Please ask for: Ms Iqraa Malik
Email: iqraa.malik@terraquest.co.uk
Telephone: 01212341390
Our Ref: WA/35/21/HH
Your Ref:
Date: 30th April 2021

Application for Planning Permission for Works or Extension to a Dwelling

Development: Erection of single storey side extension
Location: 12 Fontwell Close Walberton BN18 0SW

BLOCK PLAN 1:500

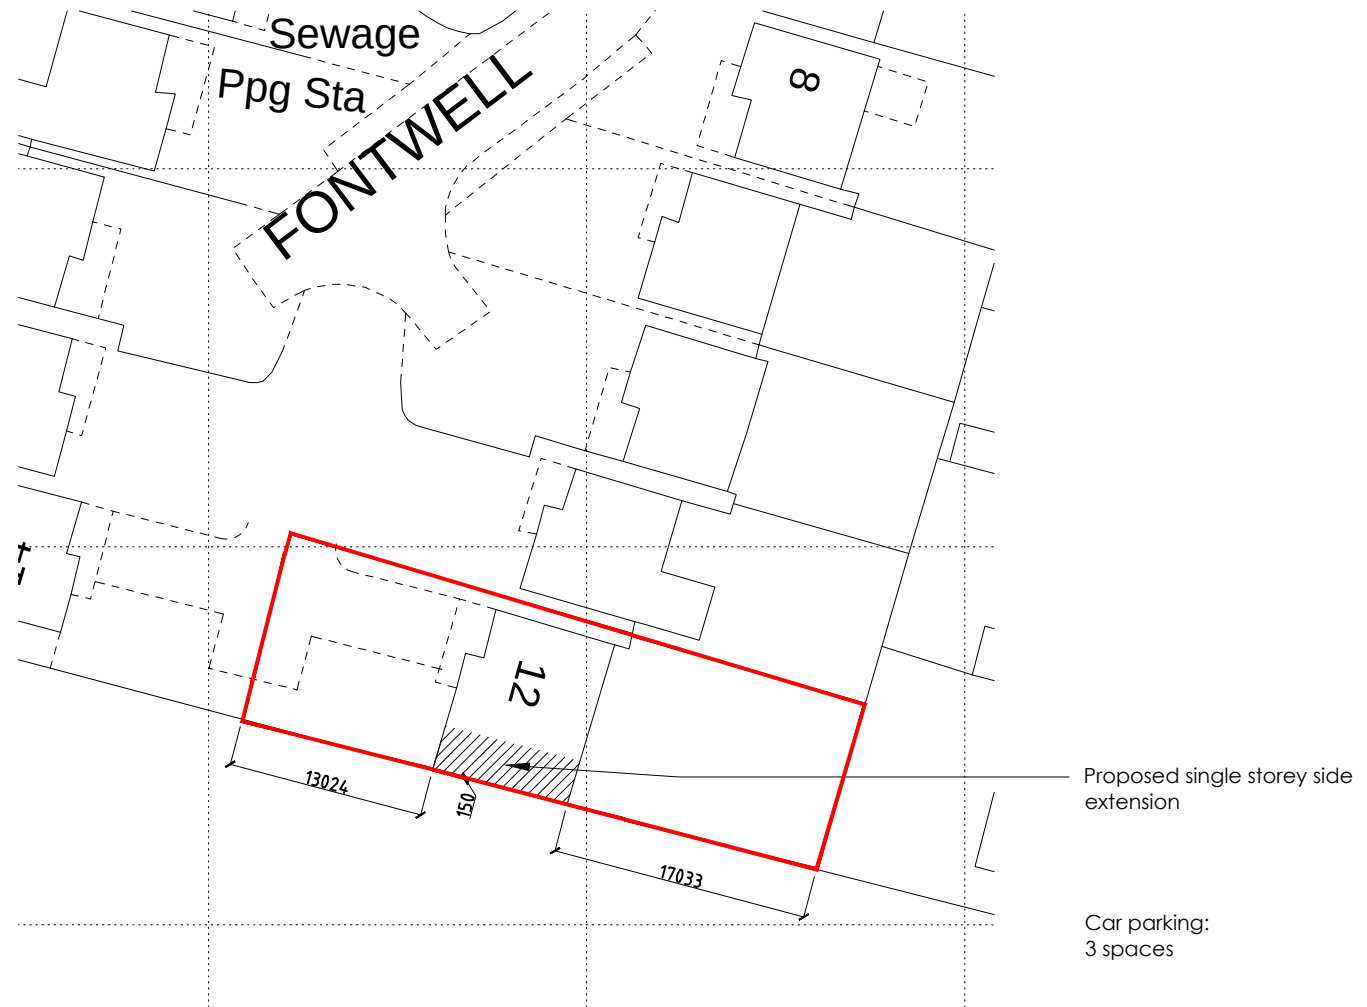
Block Plan

You are required to have dimensions from the proposed extension(s) to all site boundaries. Please amend
